Development Facilitation Team (DFT) – Review Comments

DRB Project No: PR-2022-007645 Date: 12/18/2024 Agenda Item: #2 Zone Atlas Page: J-10

Request: Minor Subdivision to vacate public easement for water and sewer, regranting against Western side of three existing lots.

Application For: SD-2024-00165 – VACATION OF PUBLIC EASEMENT

Plat for
Lots 2-A-1 thru 2-C-1, Tract S-1
Atrisco Business Park, Unit 2
 Being Comprised of
Lots 2-A thru 2-C, Tract S-1
Atrisco Business Park, Unit 2
 City of Albuquerque
 Bernalillo County, New Mexico
 September 2024

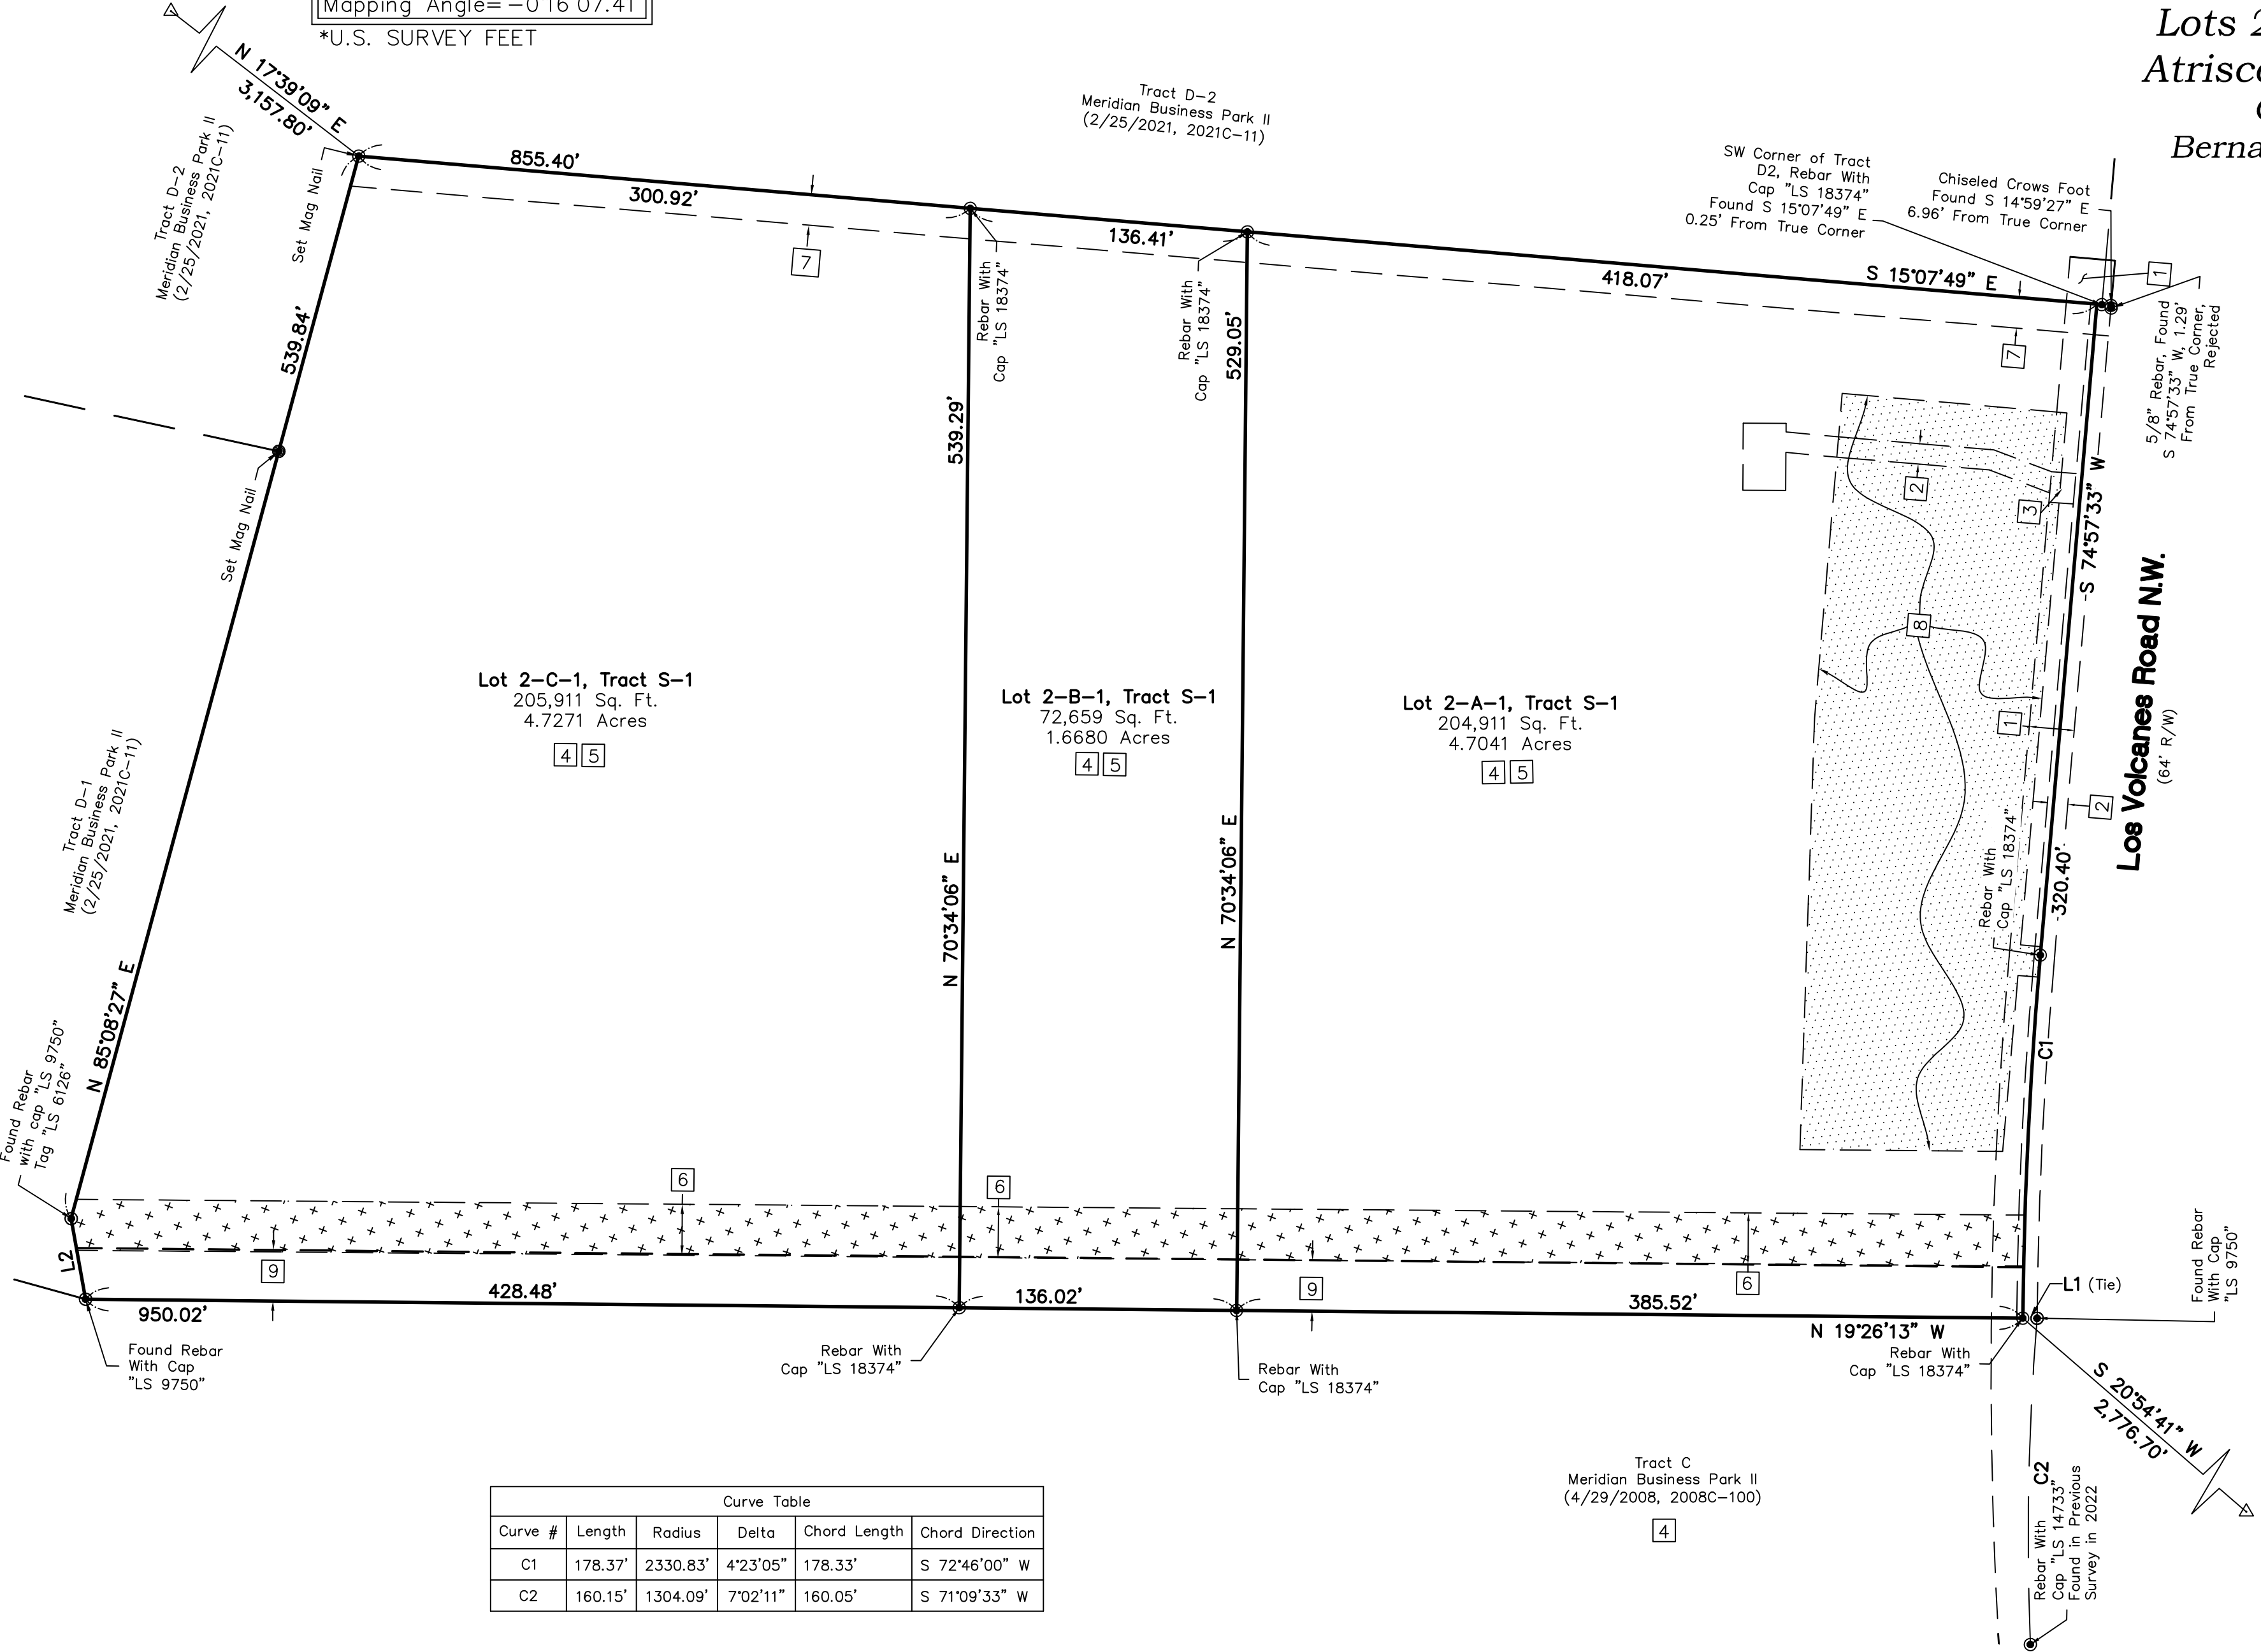
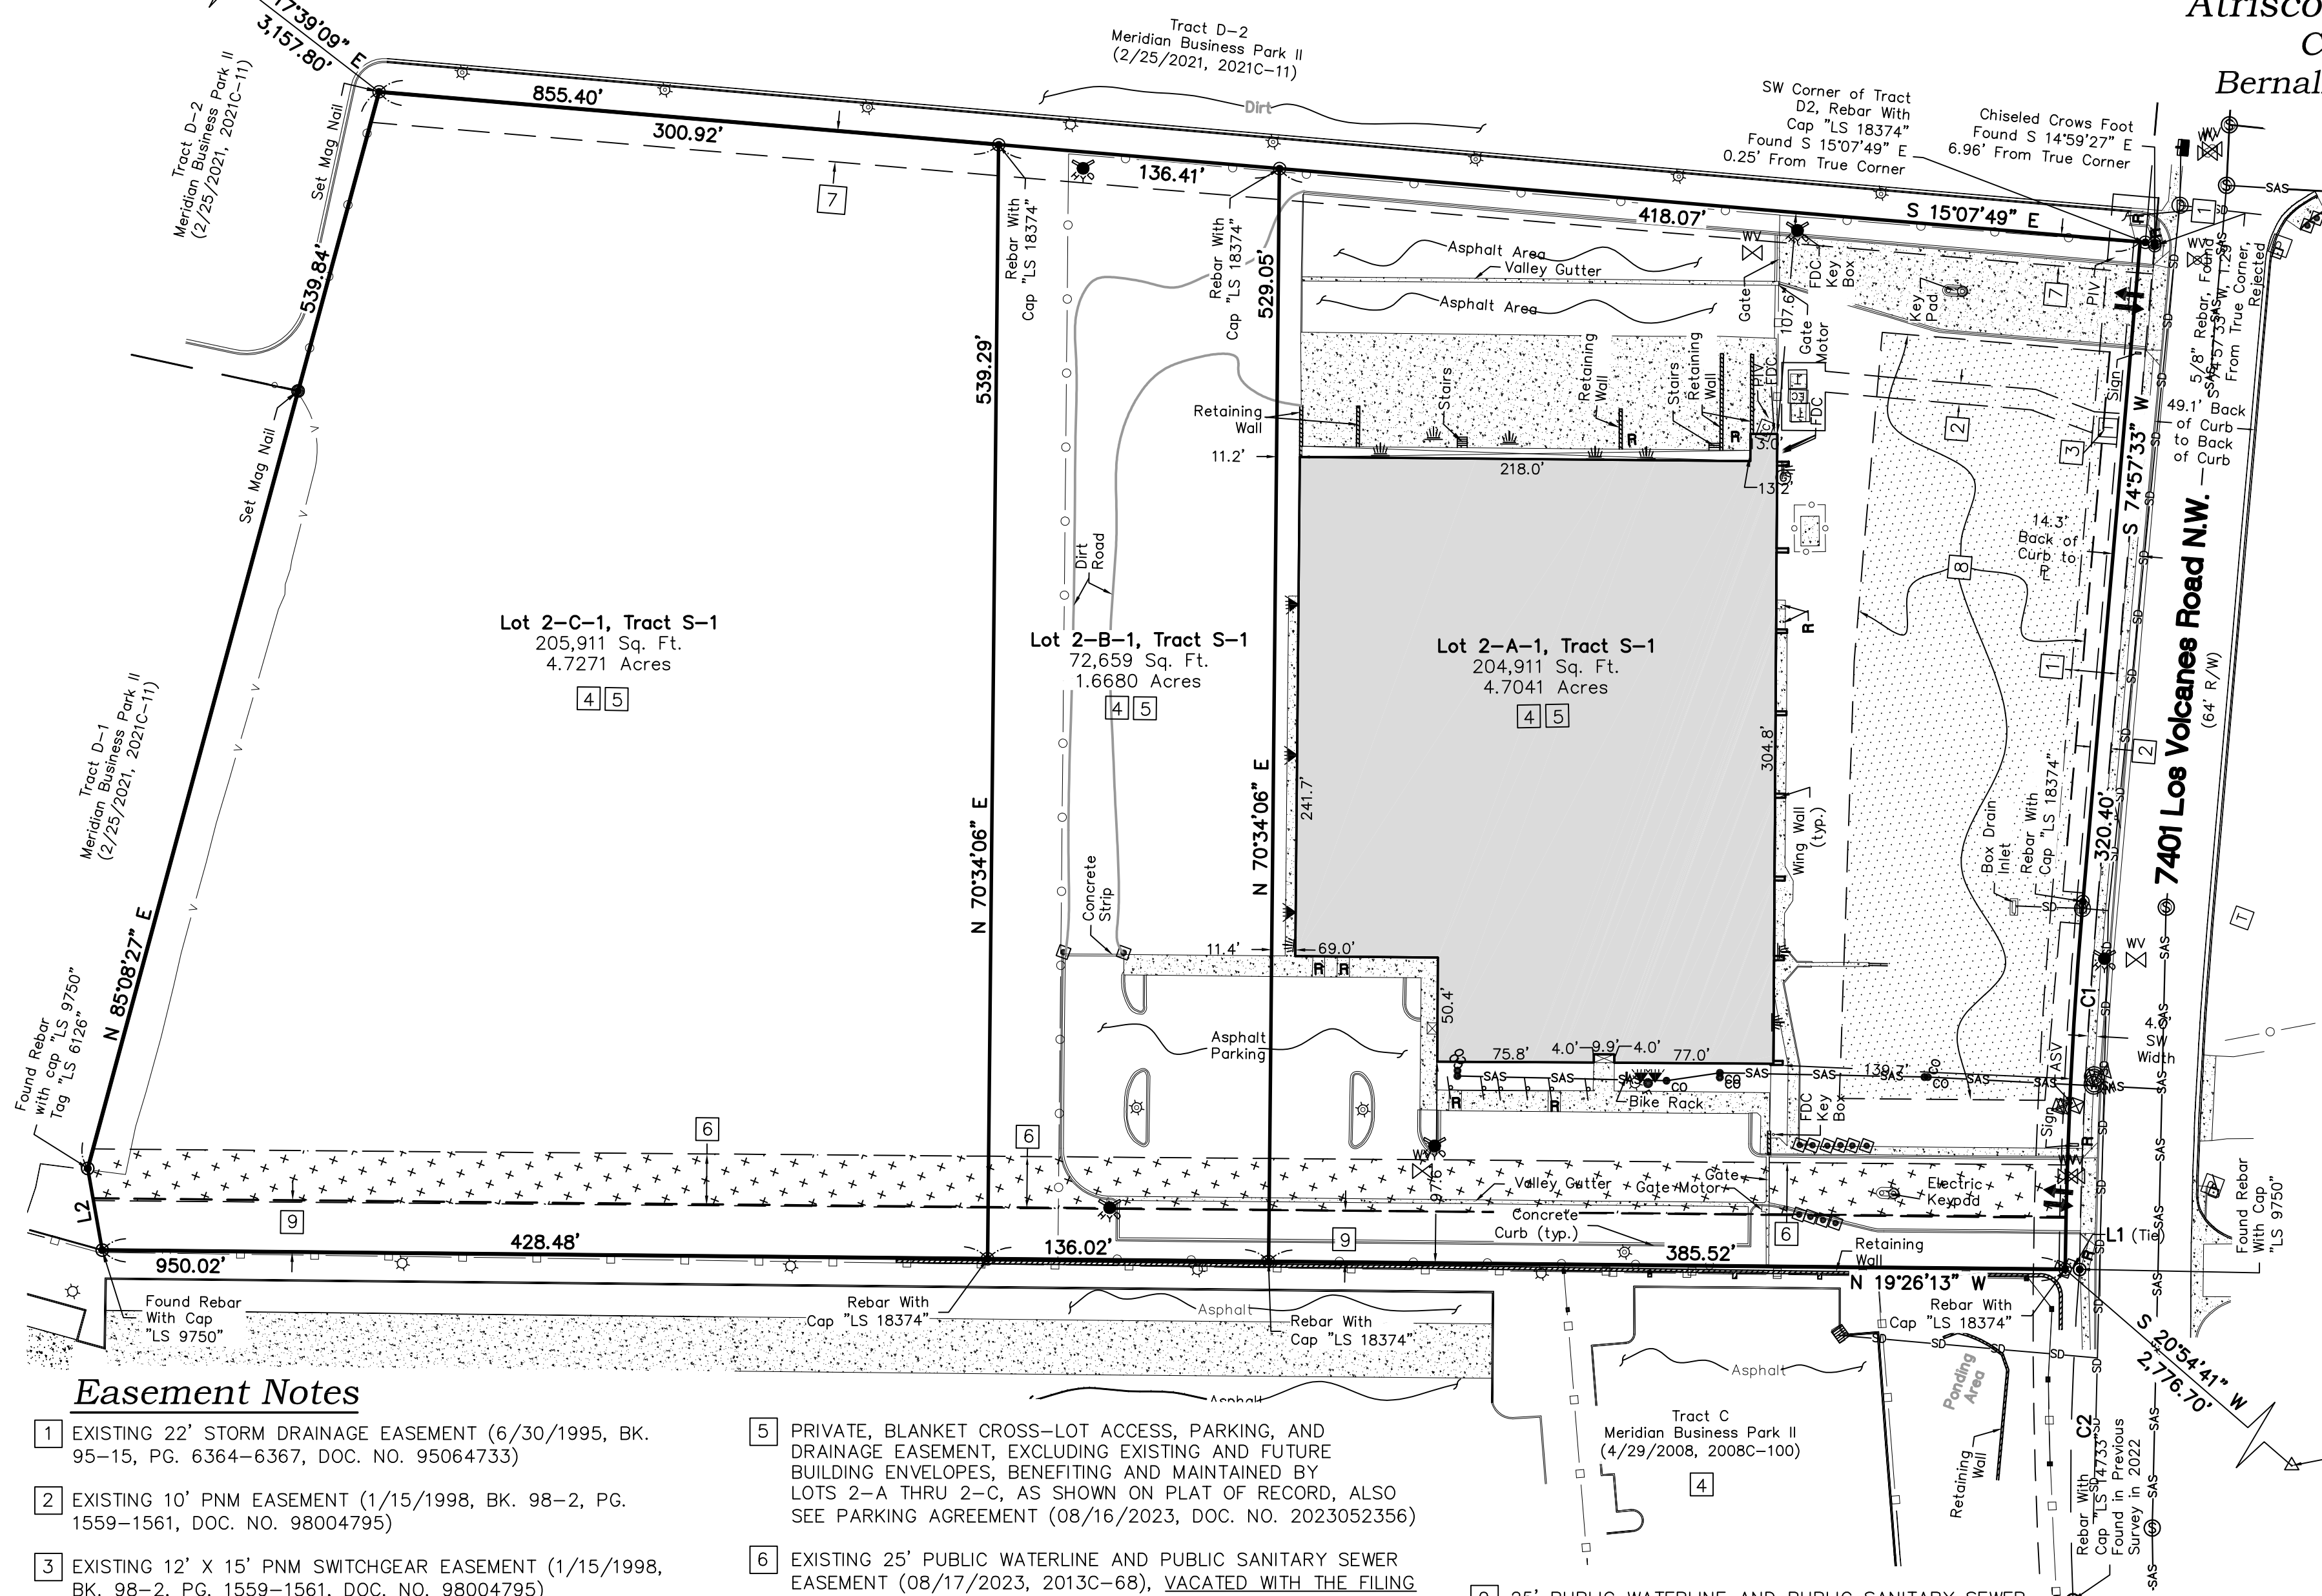
1. Confirmation with approved construction plan is needed prior to final sign off.
 2. With confirmation, I have no objections to the proposed vacation or granting of new easement with the following conditions.
 - a. Please provide a trench prism showing the infrastructure and disturbances are within the proposed easement.
 - b. Provide necessary easement bump-outs for the proposed hydrants and water service as needed.
- For reference please provide distances from edge of easement to the waterline and sanitary sewer
-

1. Confirmation with approved construction plan is needed prior to final sign off.
 2. With confirmation, I have no objections to the proposed vacation or granting of new easement with the following conditions.
 - a. Please provide a trench prism showing the infrastructure and disturbances are within the proposed easement.
 - b. Provide necessary easement bump-outs for the proposed hydrants and water service as needed.
- For reference please provide distances from edge of easement to the waterline and sanitary sewer

- The application number must be added to the Plat.
- The AGIS office must approve the DXF file and proof of approval must be provided prior to final sign-off of a plat.

- A minor change to the infrastructure was submitted. This change must be approved.
- The date of the DHO approval shall be recorded on the Plat, per 6-6(K)(2)(k) of the IDO.

- Previously this project location had an approved Platting action and Site Plan. Within those submittal/approvals, there was an approved Landscaping Plan. There are trees in the new easement and vacated easement areas. An amendment to the Site Plan/Landscaping Plan approval will be needed in order to revise tree, and possibly shrub, locations to both avoid the utility easement and also to **meet the full standards within IDO section 5-6**. Please clarify and confirm that the required standards for IDO section 5-6-G are being met.
